MESA TOP DRIVE SOUTH BRIDGE

ELITE PROPERTIES of AMERICA, INC

Contech Superstructure Plans_r1.pdf Markup Summary

DATE: 7/24/2020
 DESIGNED: NBE DRAWN: RDH
 CHECKED: NBE APPROVED: NBE
 PROJECT No.: 621715 SEQUENCE No.: 030
 SHEET: 2 OF 10

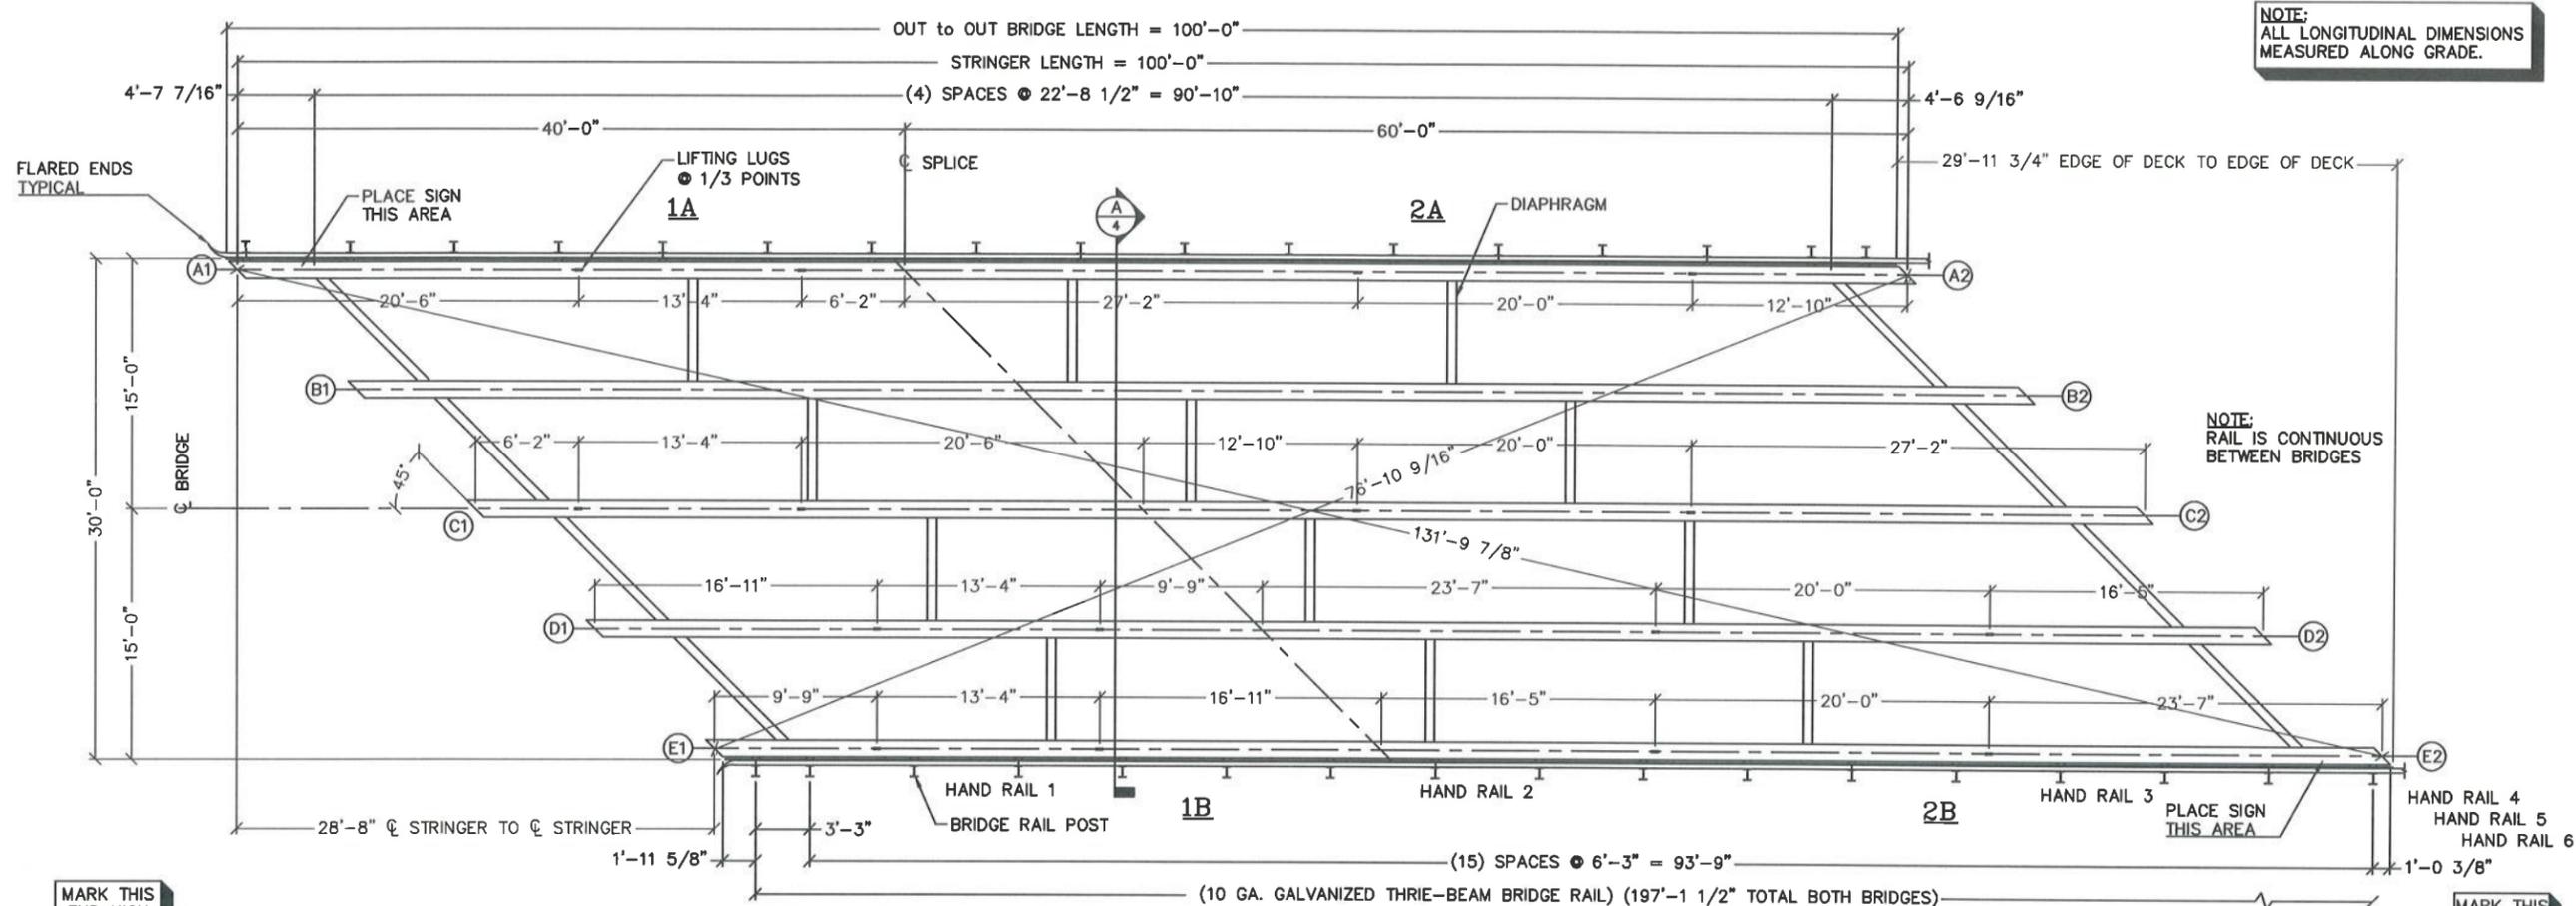
What is the specific girder size?

Substructure Plans call out CDOT Concrete Class D, with an $f'c = 4500$ psi

Substructure plans call out CDOT Concrete Class D (Bridge)

SHEET: 3 OF 10

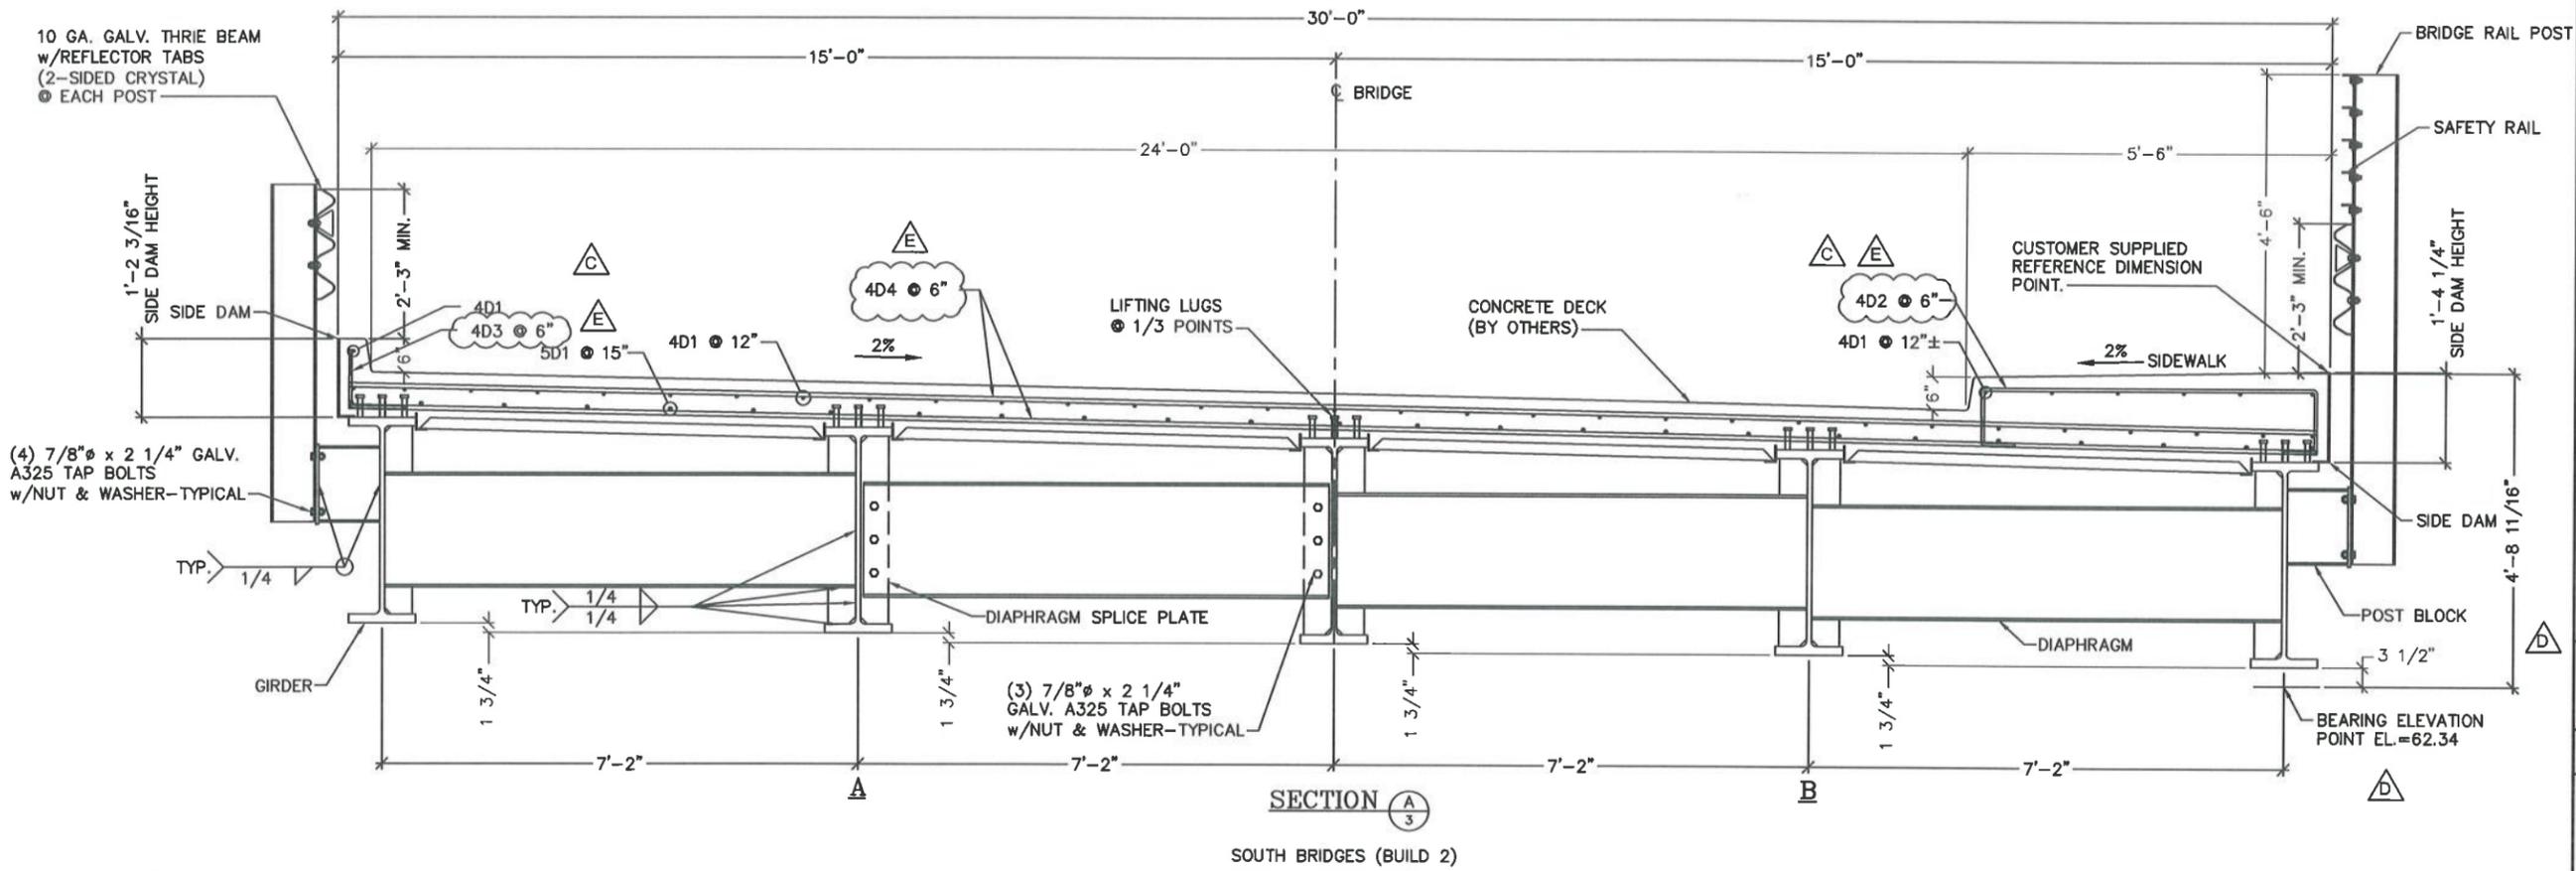
Spacing of reinforcing steel seems high. Would like to see deck design calculations.
